Response to WSCC comments December 2017.

**WEST SUSSEX COUNTY COUNCIL
PLANNING SERVICES CONSULTATION**

SUBJECT: LU/278/17/RES - Approval of Reserved Matters following Outline Permission LU/47/11 for Construction of the southern section of the Lyminster Bypass, including northern and southern roundabouts, surface water drainage and landscaping. Departure from the Development Plan & affects a Public Right of Way.

LOCATION: North Littlehampton Strategic Development Site, Land West of Toddington Park, Toddington Lane, Littlehampton, BN17 7PP.

Landscape Proposals: SLB4
Southern roundabout

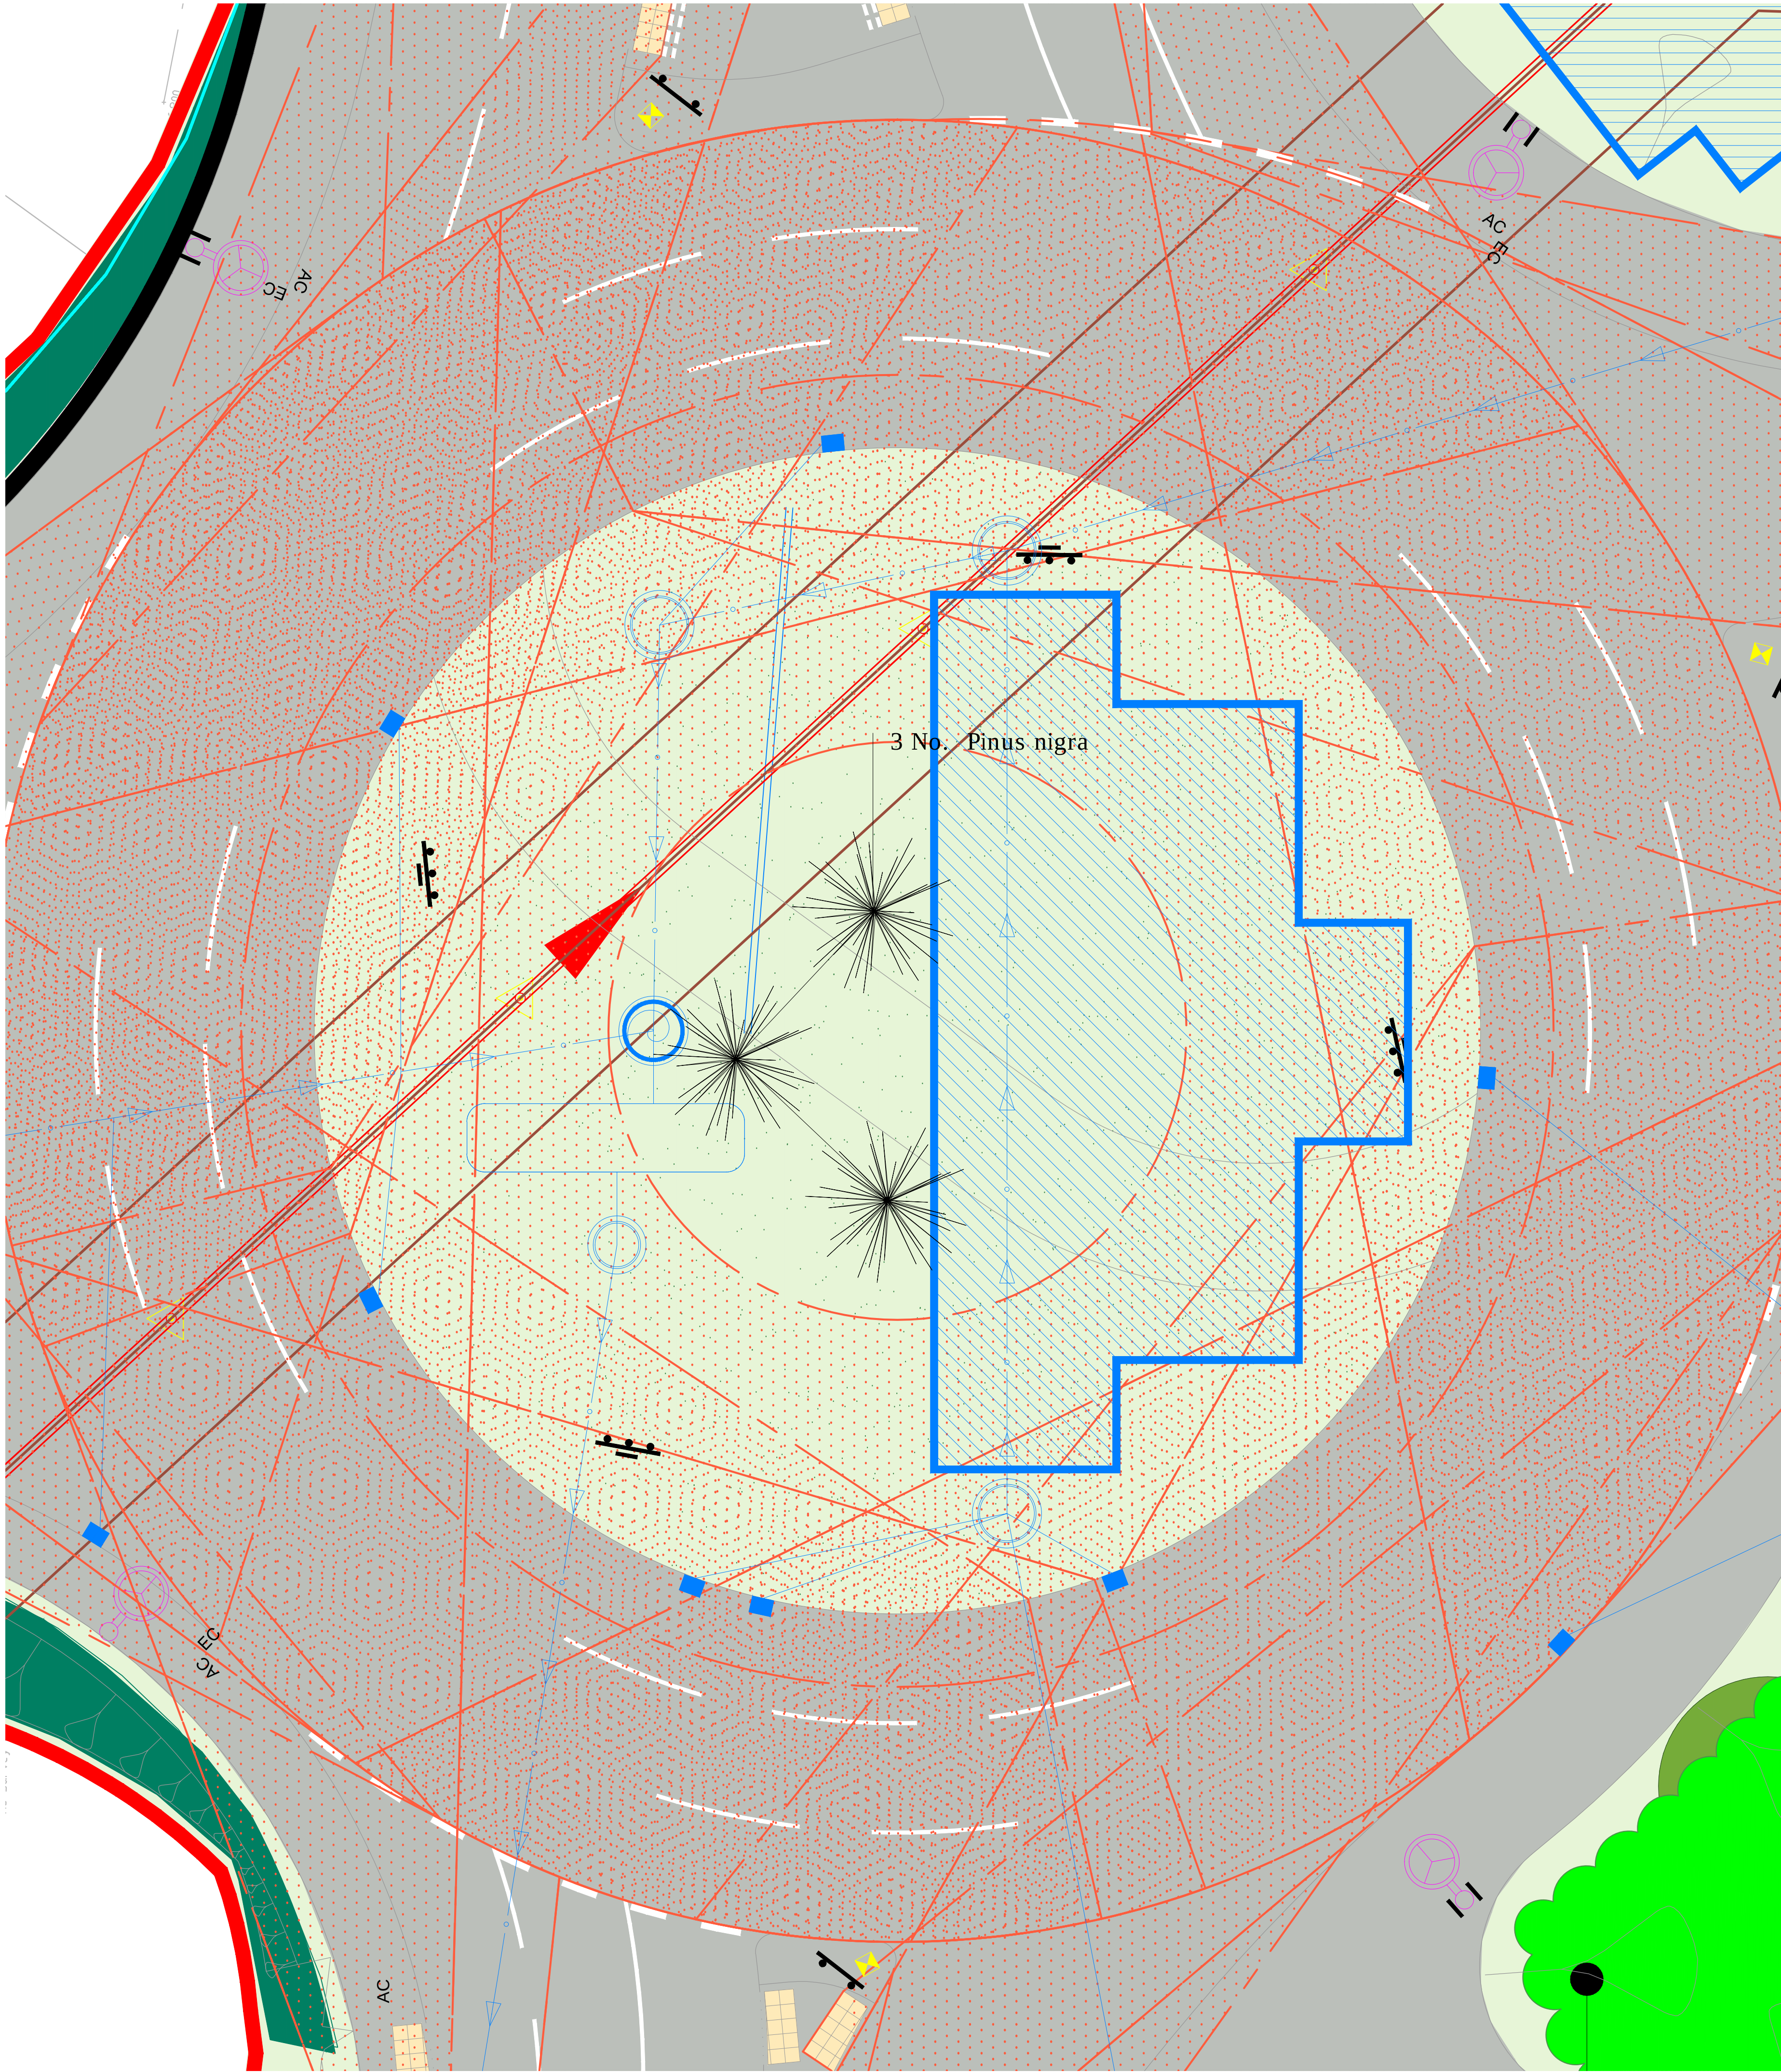
There should be no planting on the cellular storage areas, other than grass. WYG Landscape Response: Changes made

The wooden sleepers on the roundabout islands should be removed as they present a hazard should traffic collide with them. Such features would also hinder maintenance to the underlying cellular drainage system. WYG Landscape Response: Noted. The timber features have been removed and replaced with soft landscaping where it can be accommodated.

Timber features and ground-cover ivy have been removed from both roundabouts. **Northern roundabout:** underground storage tank has been removed. Pine trees and ground-cover pine are proposed within the centre of the roundabout (outside the visibility splays). **Southern roundabout:** Storage tank remains. Pine trees are proposed within the centre of the roundabout.
